**Our ref:** NO/2020/112855/04-L01  
**Your ref:** 3/2020/0601  
**Date:** 24 December 2020

**OUTLINE PLANNING FOR THE CONSTRUCTION OF UP TO 125 DWELLINGS WITH PUBLIC OPEN SPACE, LANDSCAPING AND SUSTAINABLE DRAINAGE SYSTEM AND VEHICULAR ACCESS POINT FROM HIGHMOOR PARK. ALL MATTERS RESERVED EXCEPT FOR MEANS OF ACCESS.  
LAND AT HIGHMOOR FARM, CLITHEROE, BB7 1PN**

**Environment Agency position**

Drawing title: Flow Exceedance Plan

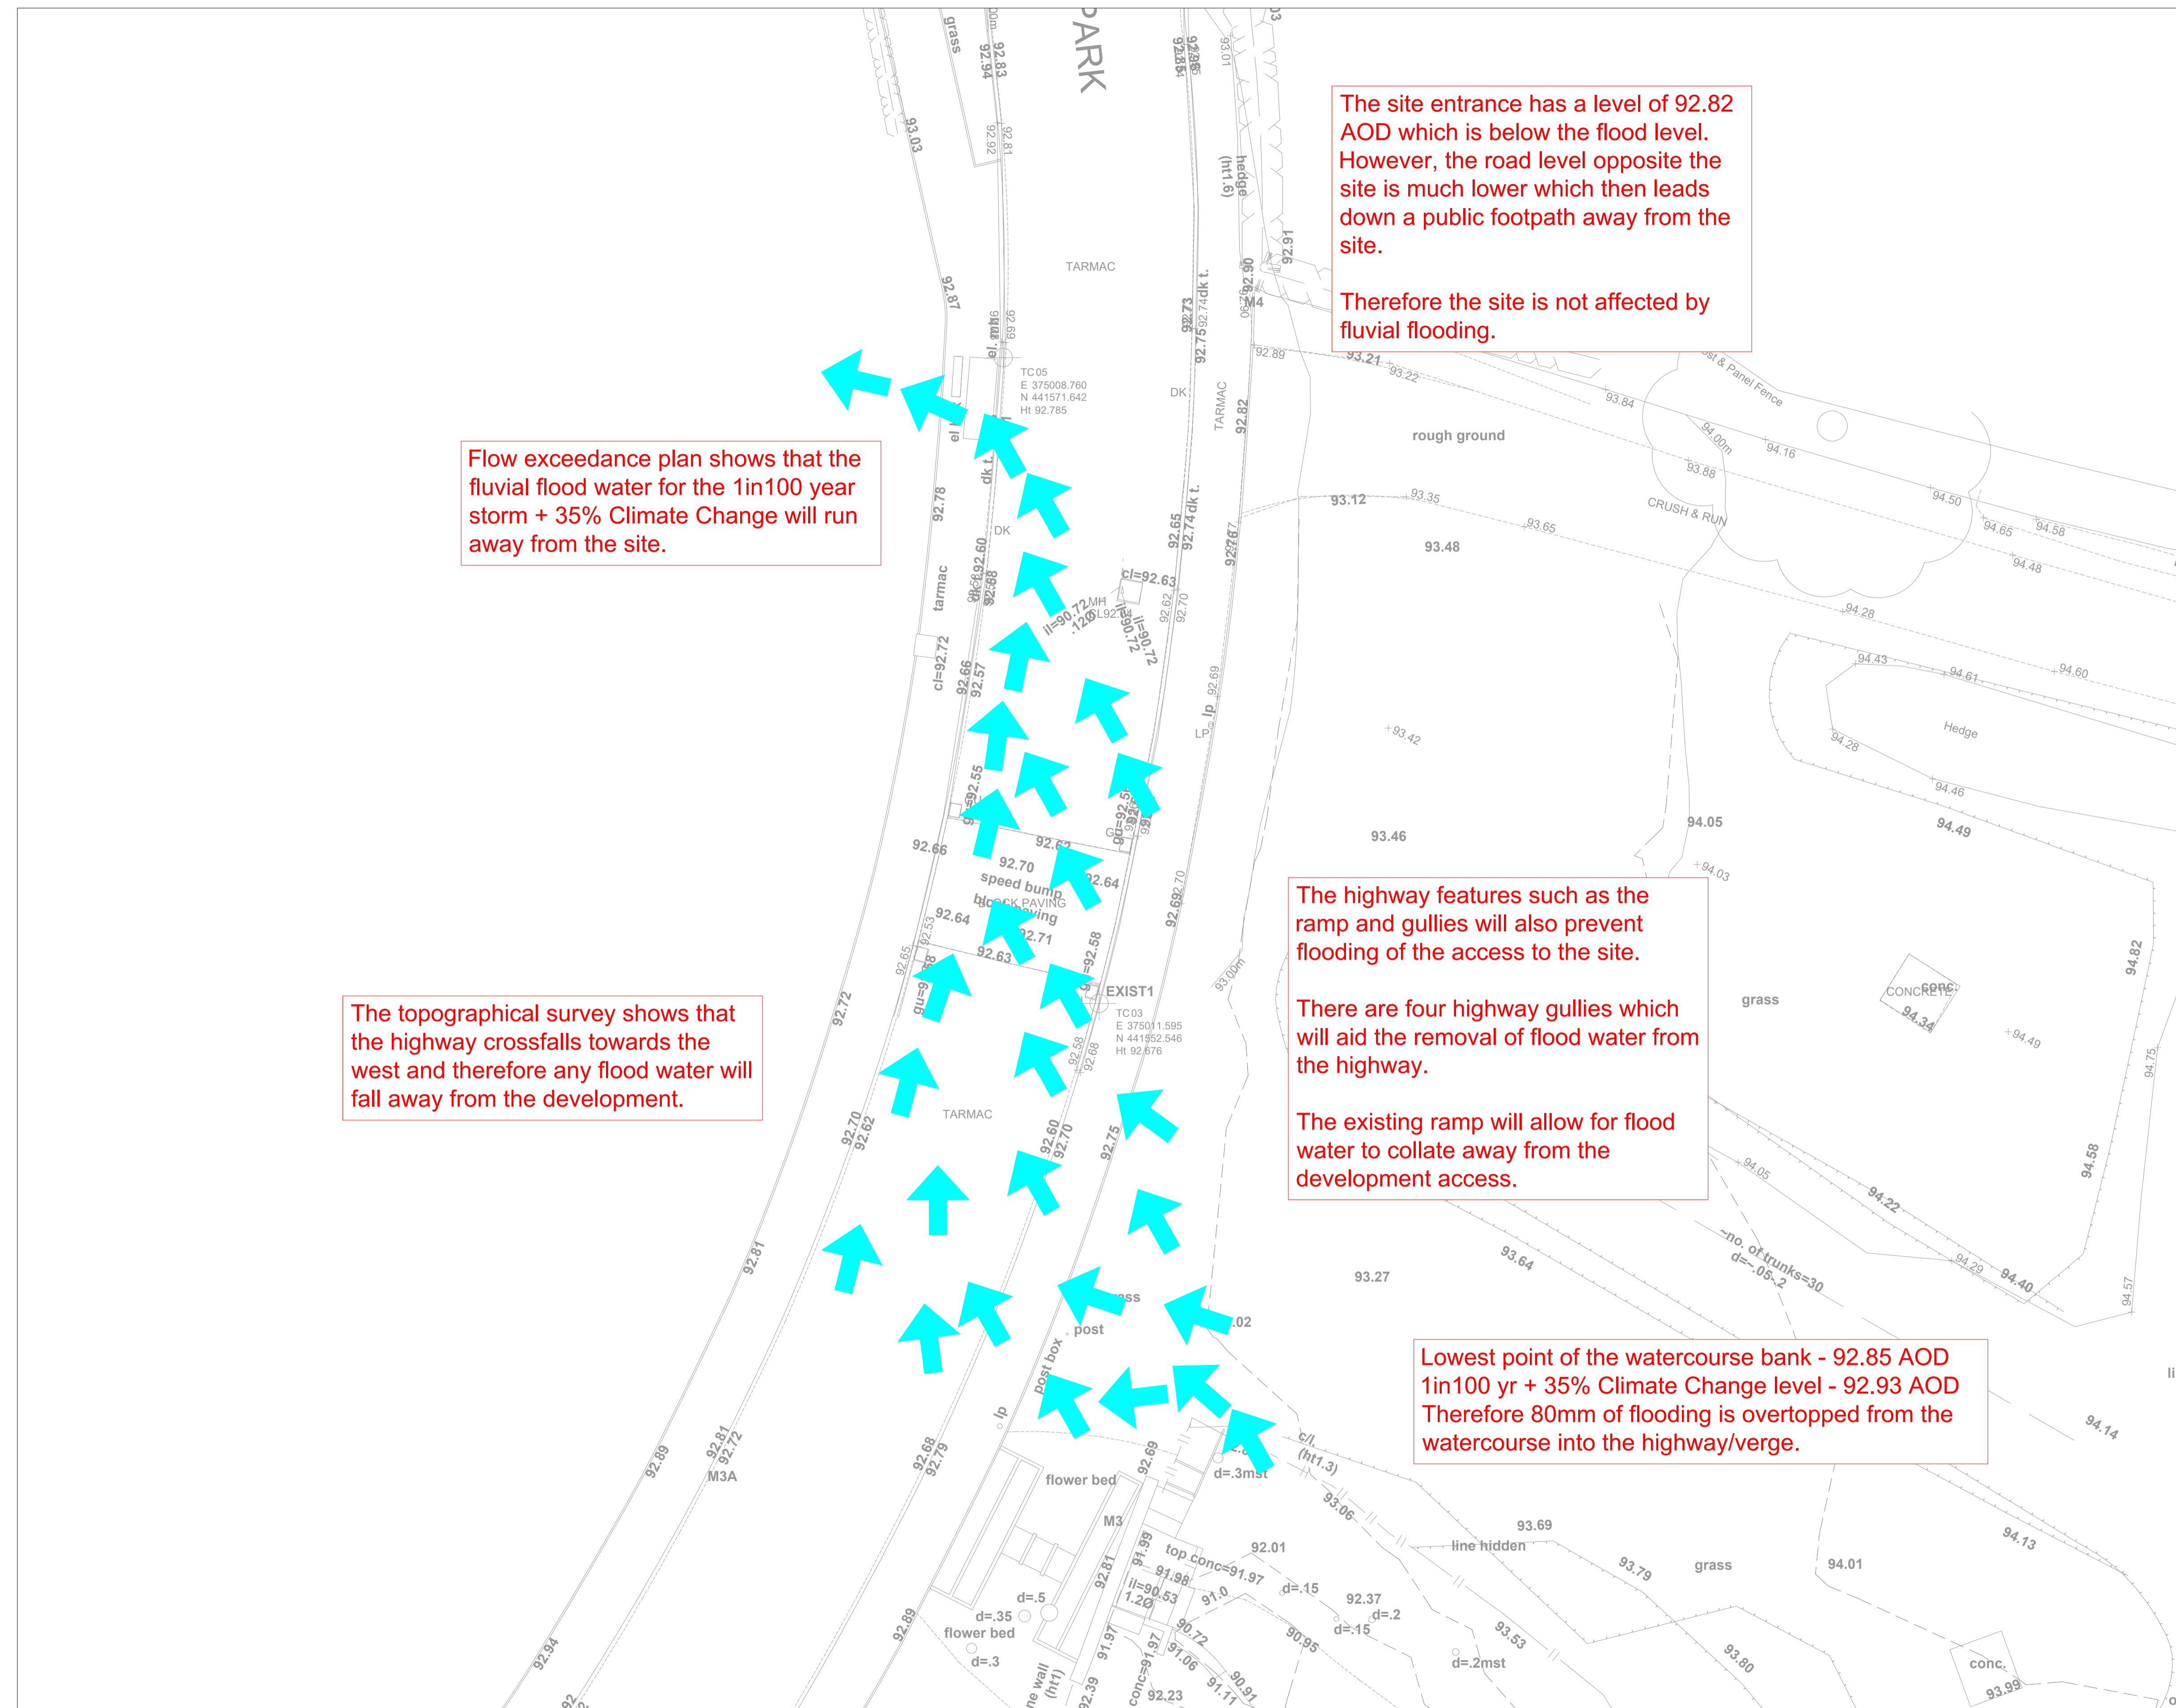
To overcome our objection, the applicant should provide further detail and assessment of the proposed river bank raising and compensatory storage scheme. Access and egress routes in the event of a flood must also be outlined.

We also note that the above mentioned works may be disproportionate to the scale of flooding on the development scheme. As outlined in previous comments, it is recommended that the 100-year fluvial flood event with 35% allowance for climate change level for Shaw Brook is also assessed. These modelled levels should form part of the fluvial flood risk assessment for the site, the assessment should also include analysis of flood depths, extents etc. and the risks these pose. Mitigation measures implemented must not increase flood risk to people and property elsewhere. Access and egress routes to the site in a flood event must also be detailed within the FRA.
